# Rezoning Transportation Analysis

Petition Number: 2021-100

General Location Identifier: 02761107

| Date      | Description        |
|-----------|--------------------|
| 8-20-2021 | First Review (DBS) |

CONCEPT
SITE PLAN

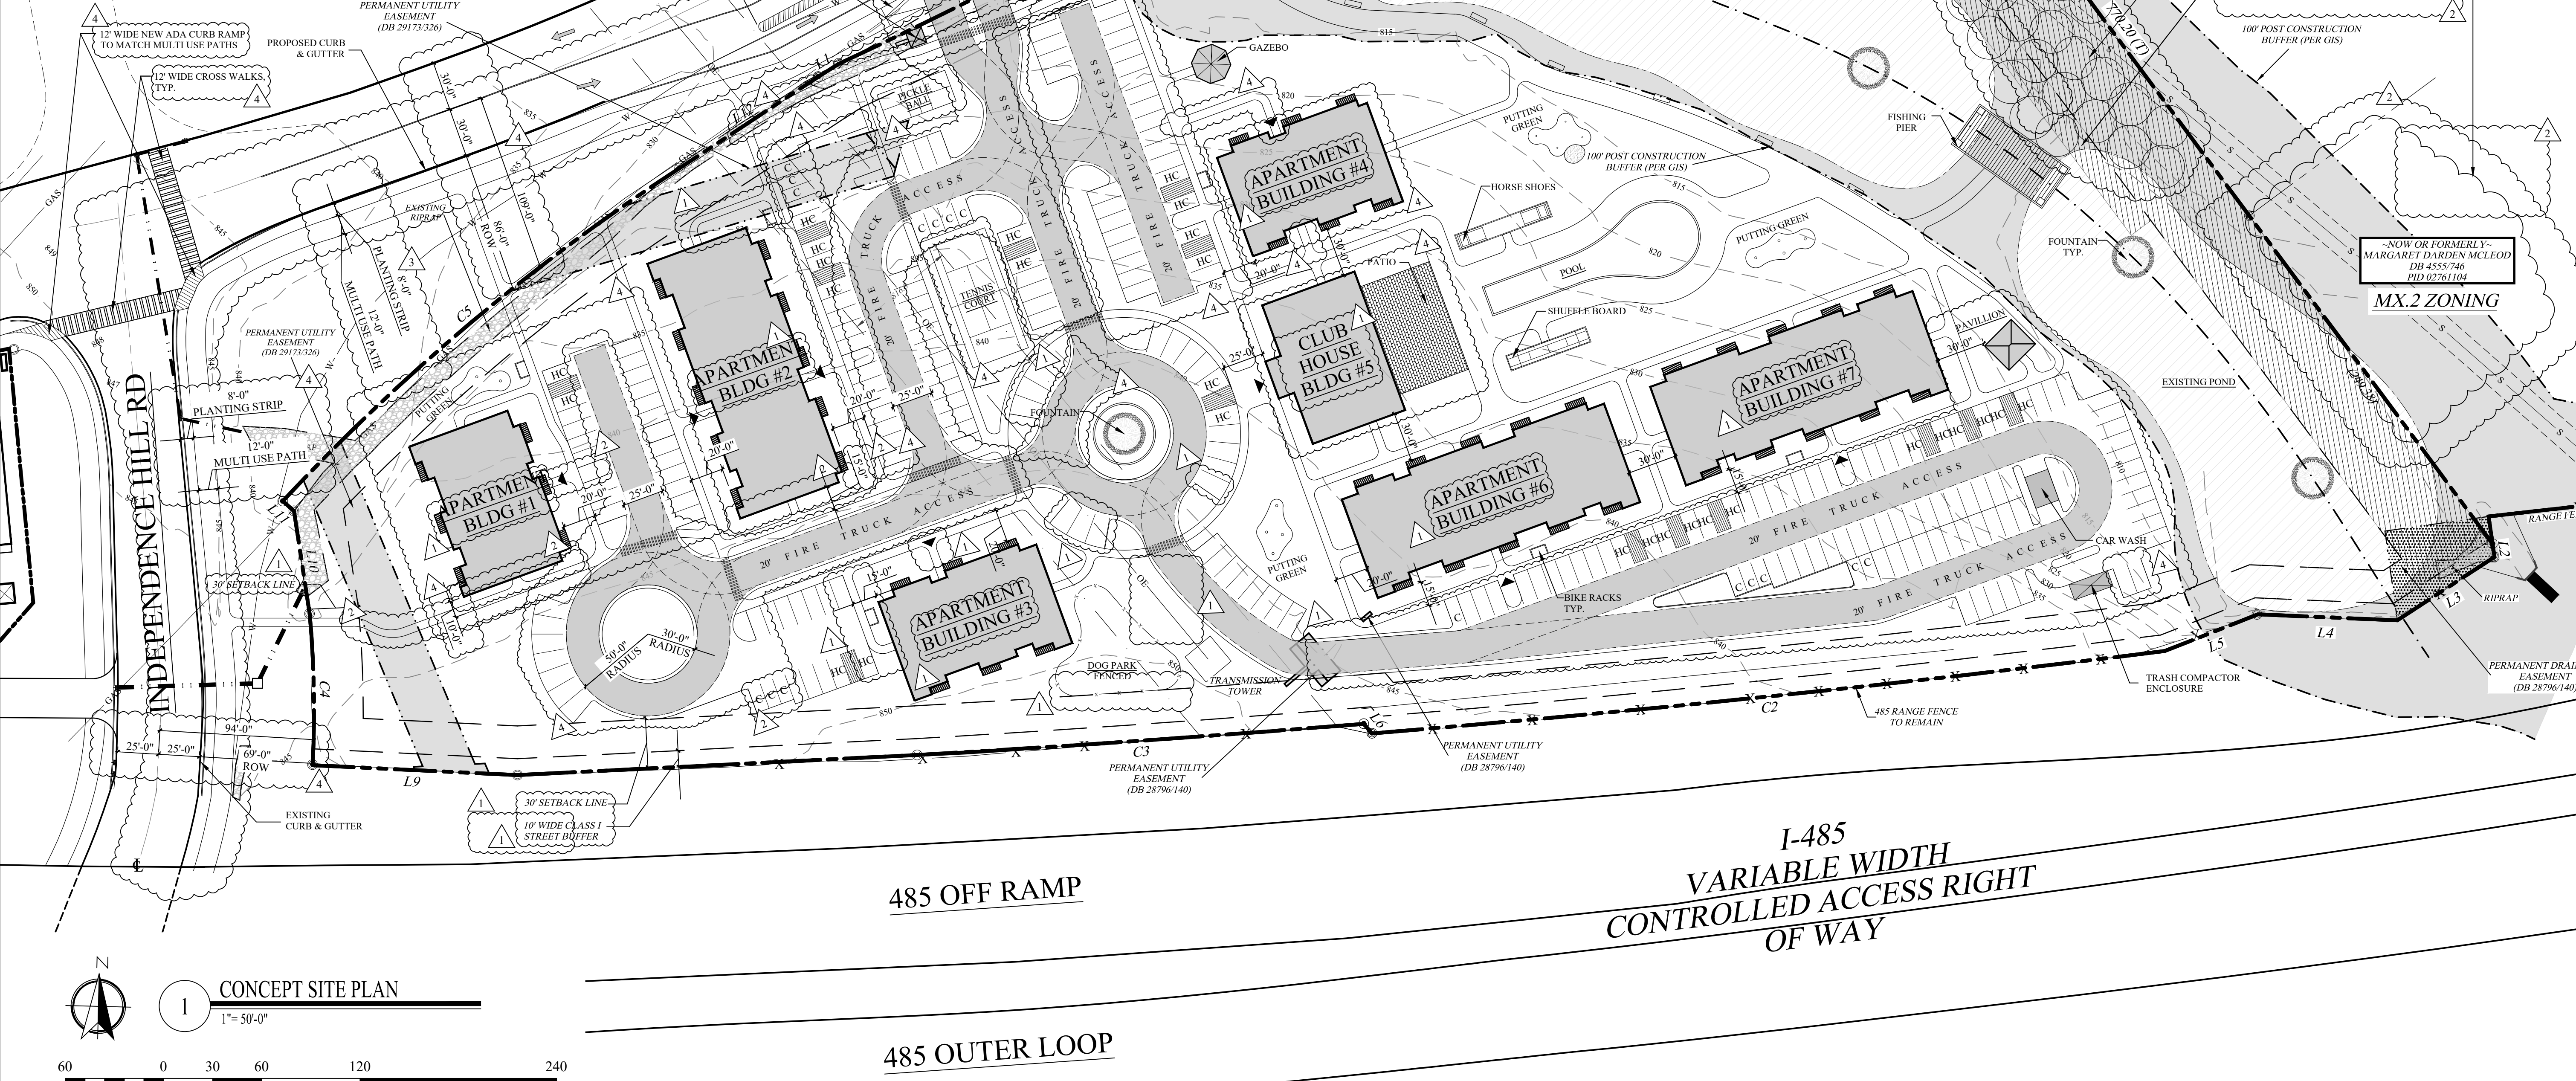
1. The curbline along Eastfield Road shall be shown at 30' from centerline to back of curb. Revise site plan to reflect this condition and label and dimension the right-of-way and curb and gutter from the Eastfield Road centerline.

3. Revise site plan and conditional notes to label and describe location of the existing curb location and right-of-way along Independence Hill Road. The site plan shall label and dimension the curb and right-of-way from the road centerline.

4. Revise site plan to construct 8-foot planting strips and 12-foot multi-use paths on Eastfield Road and Independence Hill Road. The site plan shall label and dimension both items from the back of curb and gutter and road centerline. Add conditional note committing to construction and maintenance of the 8-foot planting strips and 12-foot multi-use paths on Eastfield Road and Independence Hill Road since property is in the ETJ. A maintenance agreement will be required for these facilities.

6. Revise site plan and add conditional notes showing access points off of Eastfield Road and Independence Hill Road to be right in-right out only.
7. If the access point on Independence Hill Road is within the limits of the I-485 controlled access, NCDOT will need to be consulted about the feasibility of the access point location.
